**CITY OF MERCER ISLAND**

August 29, 2017

RE: ADU17-003, CAO17-005, SHL17-007, SUB17-004 Second Review Letter  
Land Use Applications for proposed home, ADU, driveway and retaining wall construction within  
a steep slope along the shoreline for the Lady Bug Trust. DEV17-009 Impervious Surface  
Deviation Application has been withdrawn.

Project: 503.01
 Sheet: A2.4

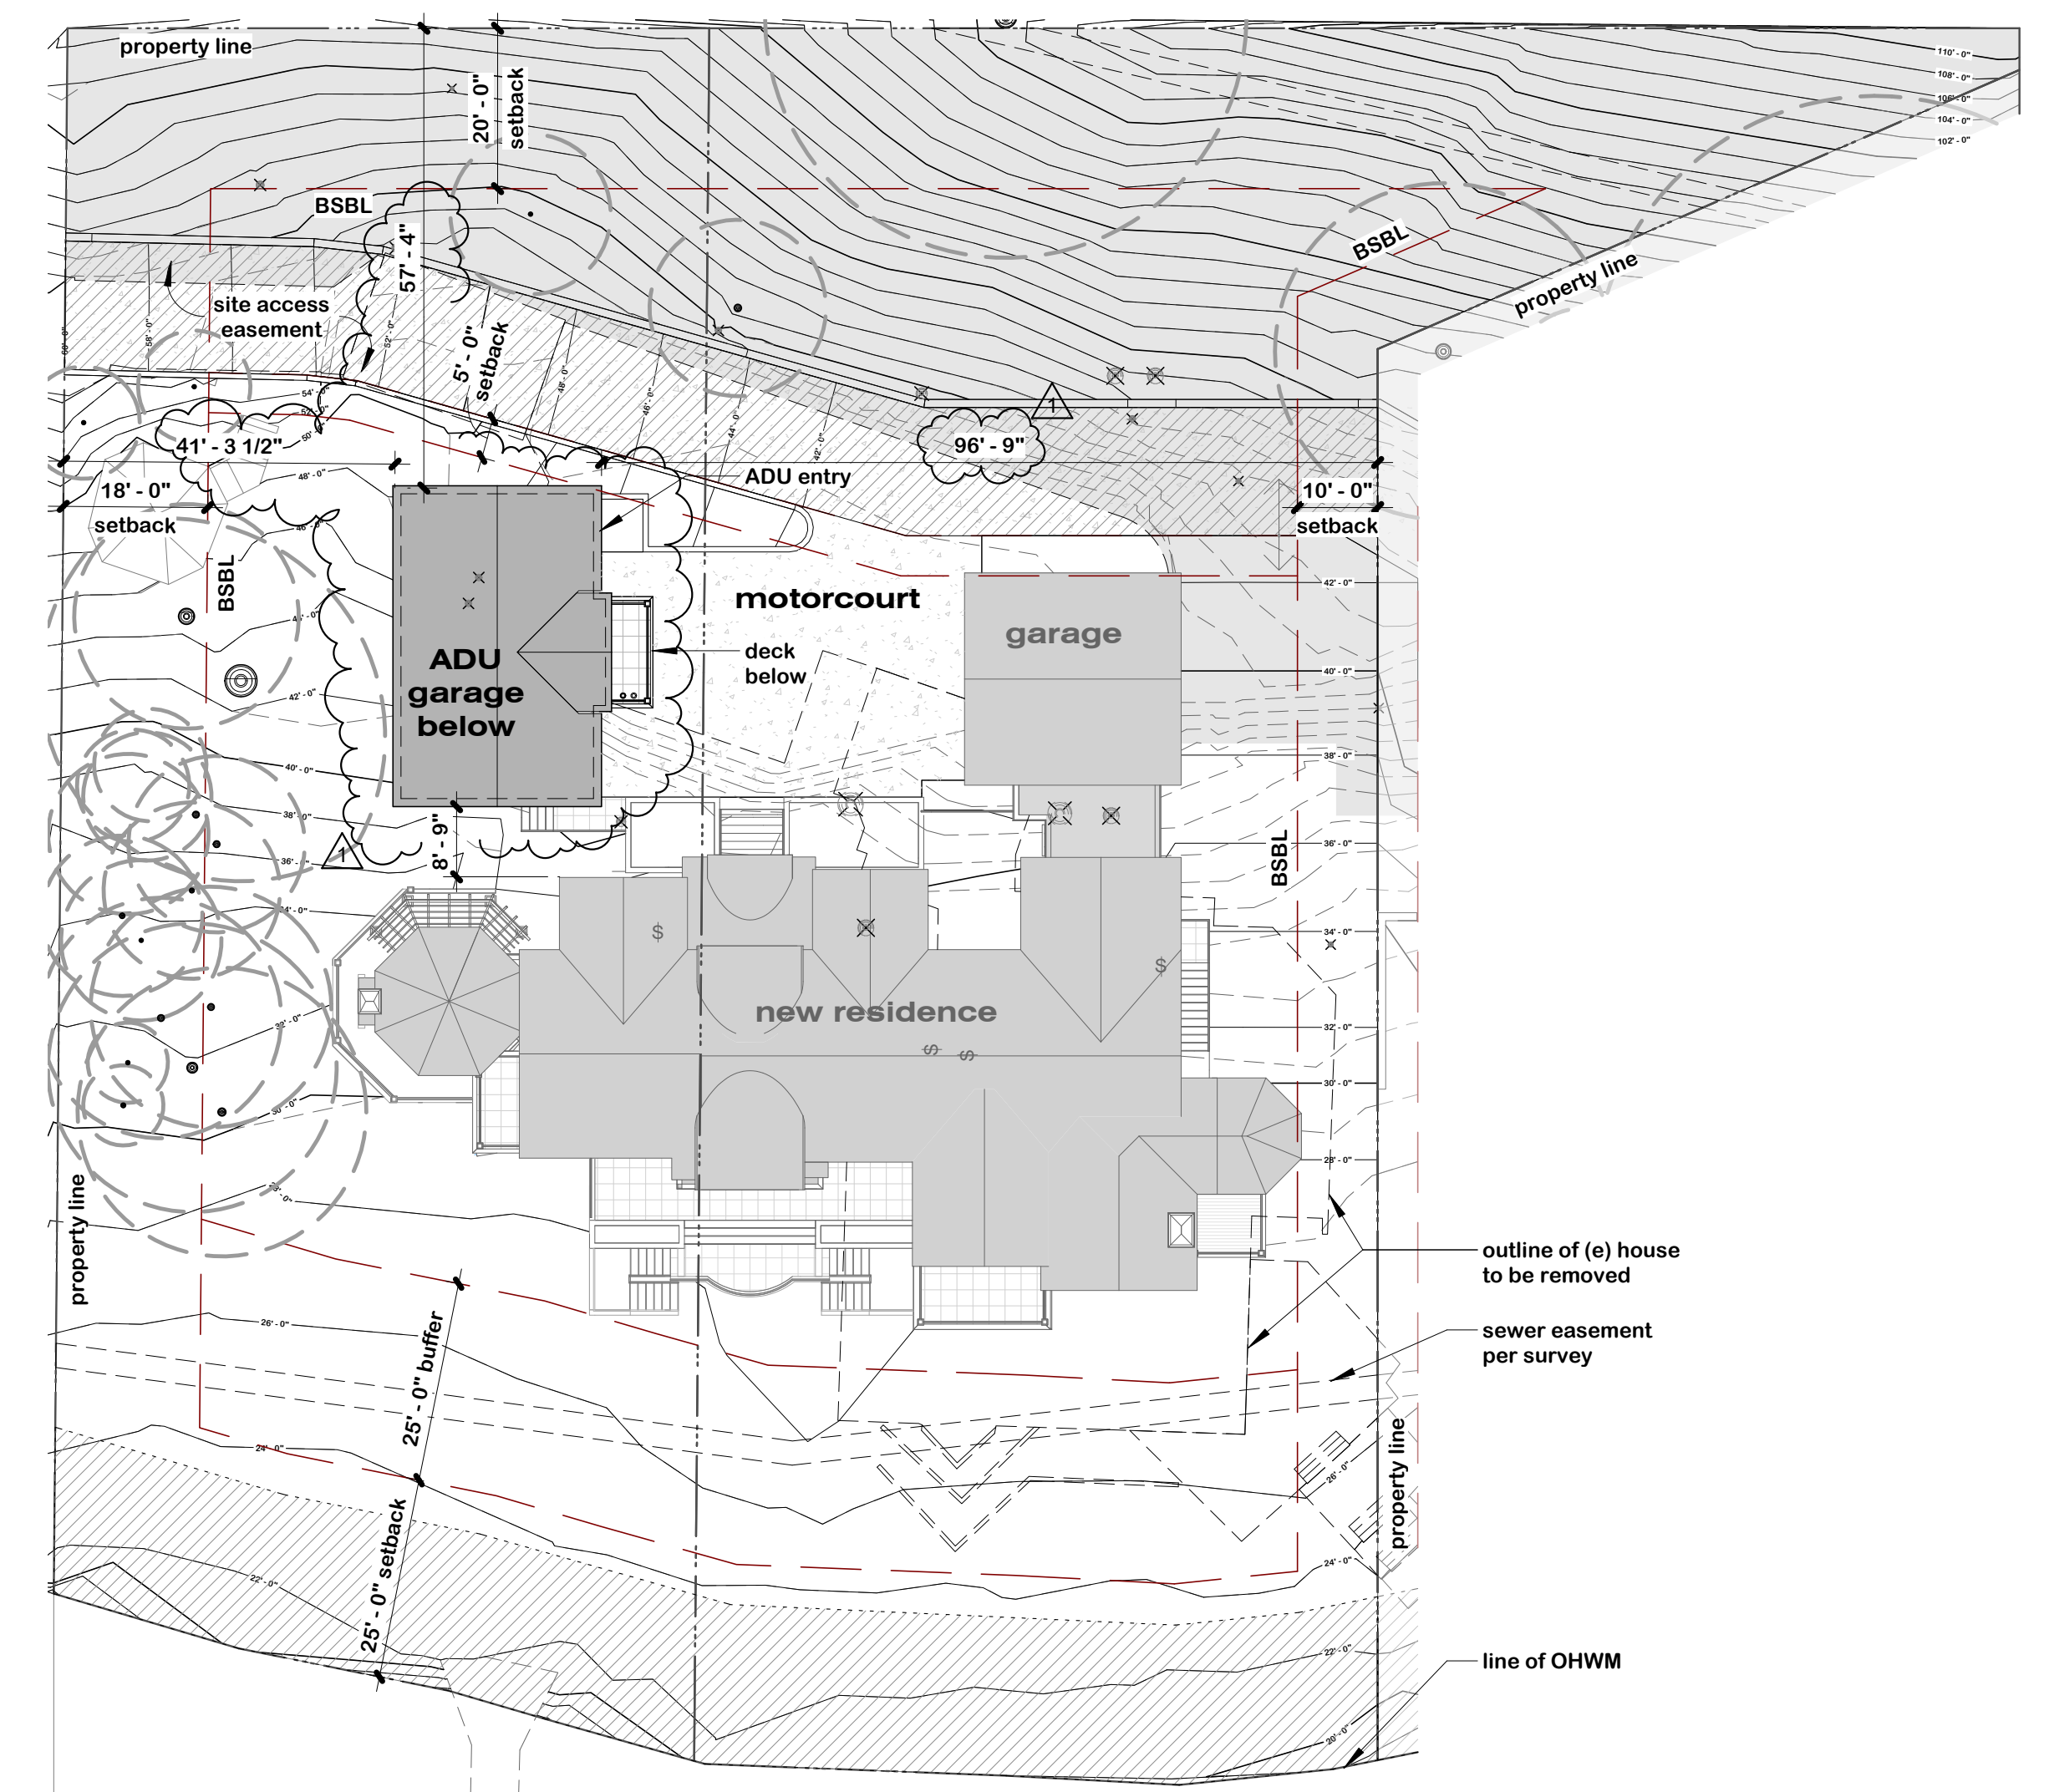
5. Please provide a Construction Management Plan (CMP), refer to the CMP Checklist provided.
6. Please label the setbacks and width on all pages on the plans.
7. On Sheet A2.4, please verify that the proposed retaining walls within the required side setbacks meet our height requirements set forth in MICC 19.02.050. The maximum height is 144 inches for cut slopes, and the proposed retaining wall 03 is in question at a maximum height of

- approximately 29 feet 9 inches. In addition, with the proposed code update, the maximum height of the retaining wall outside of the required setbacks is 17 feet. Please consult with your Geotechnical Engineer and Don Cole (Building Official) about the design of the retaining wall, possible options include stepping the retaining walls and/or raising the driveway from the current proposal (still must meet maximum driveway grade of 20%).

1 ADU - south elevation
1/4" = 1'-0"

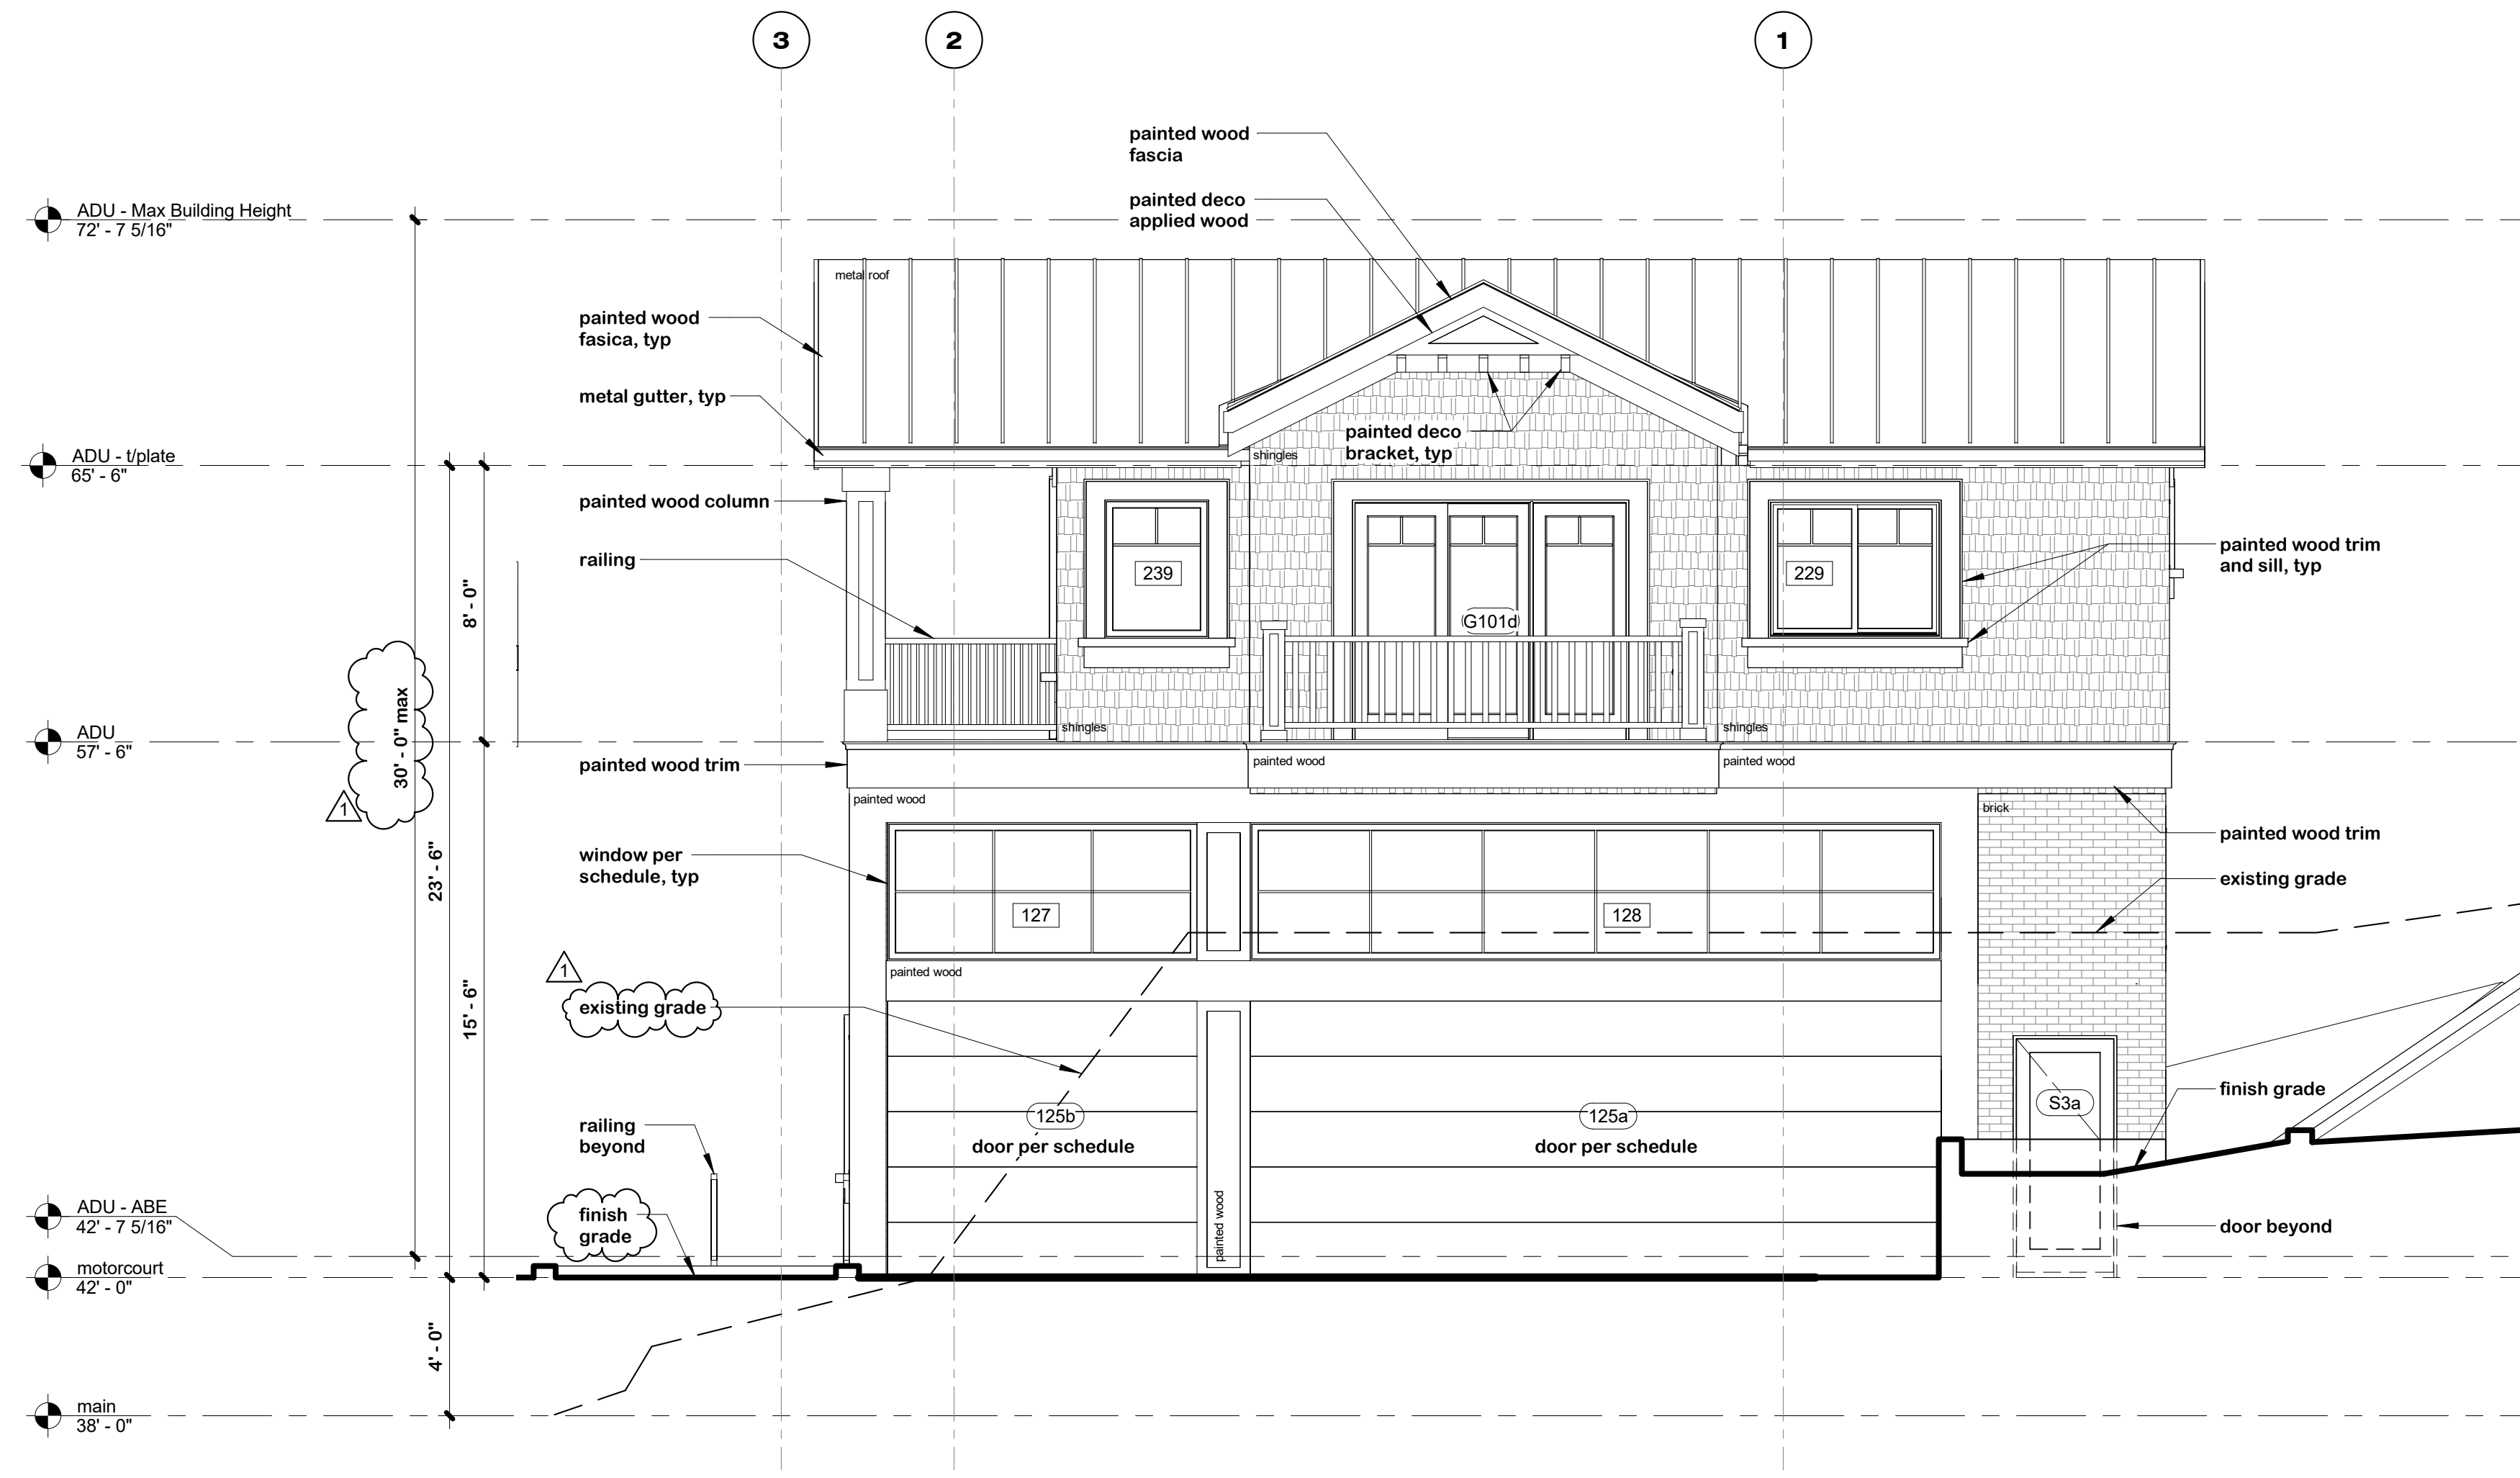
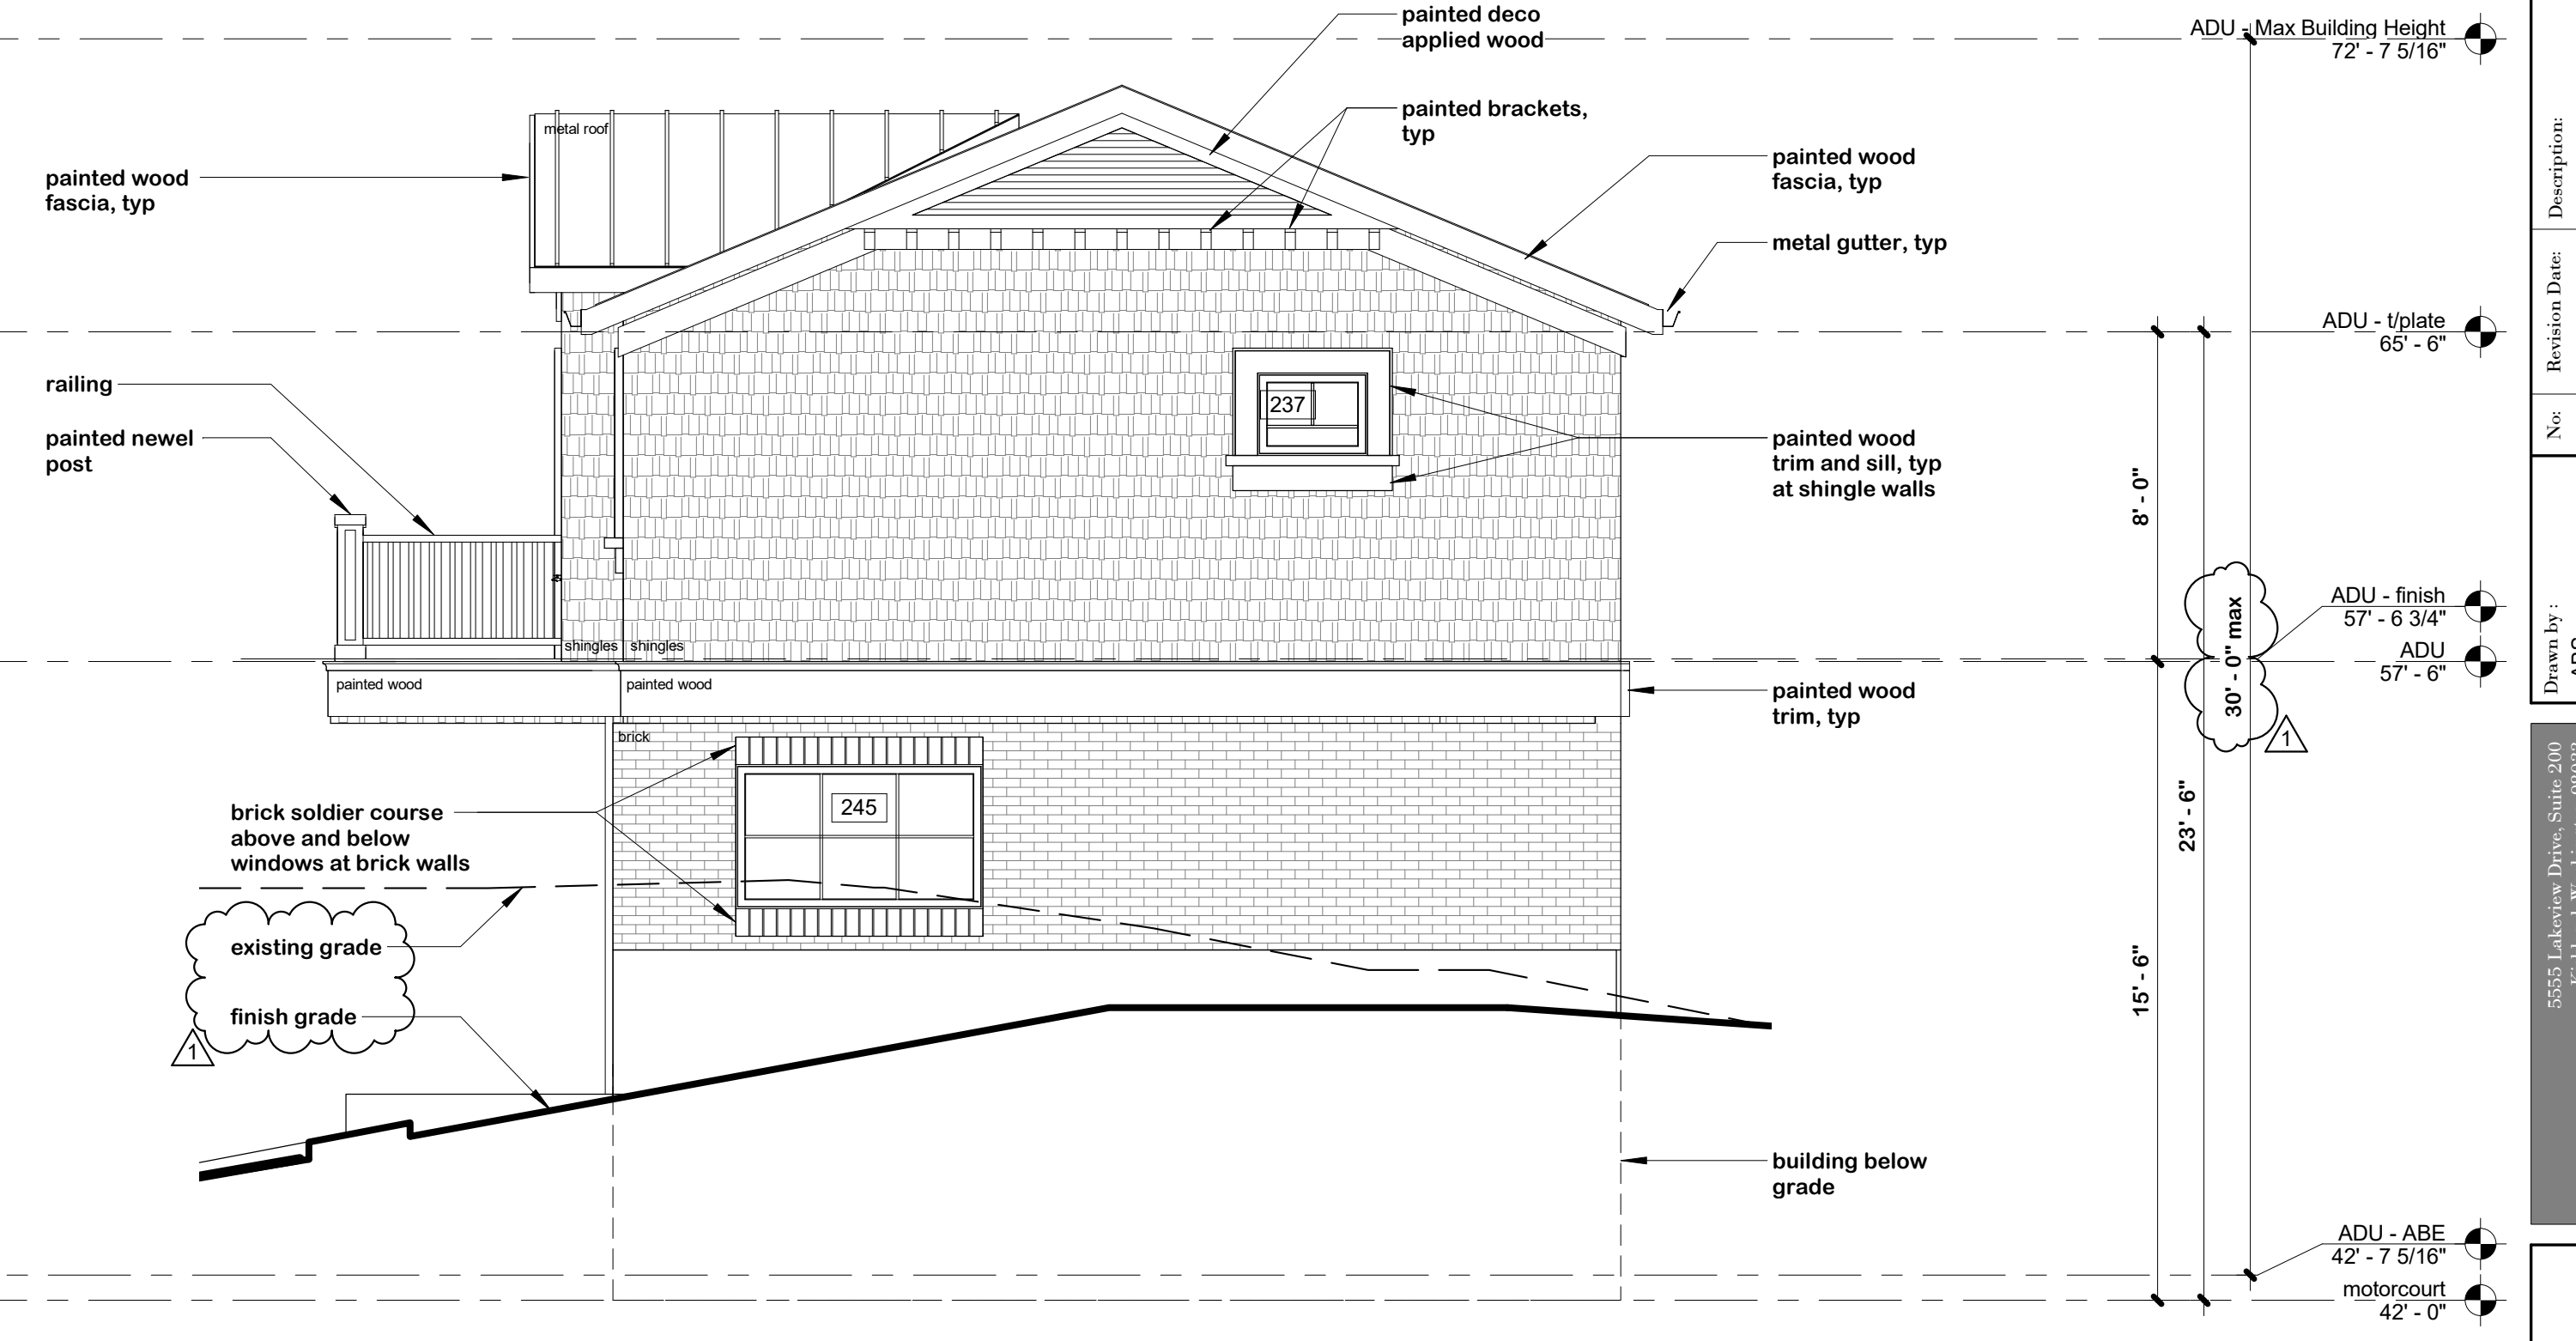
8. Please provide building elevation drawings that the ADU shall be designed consistent with the existing roof pitch, siding, and windows of the principal dwelling unit.
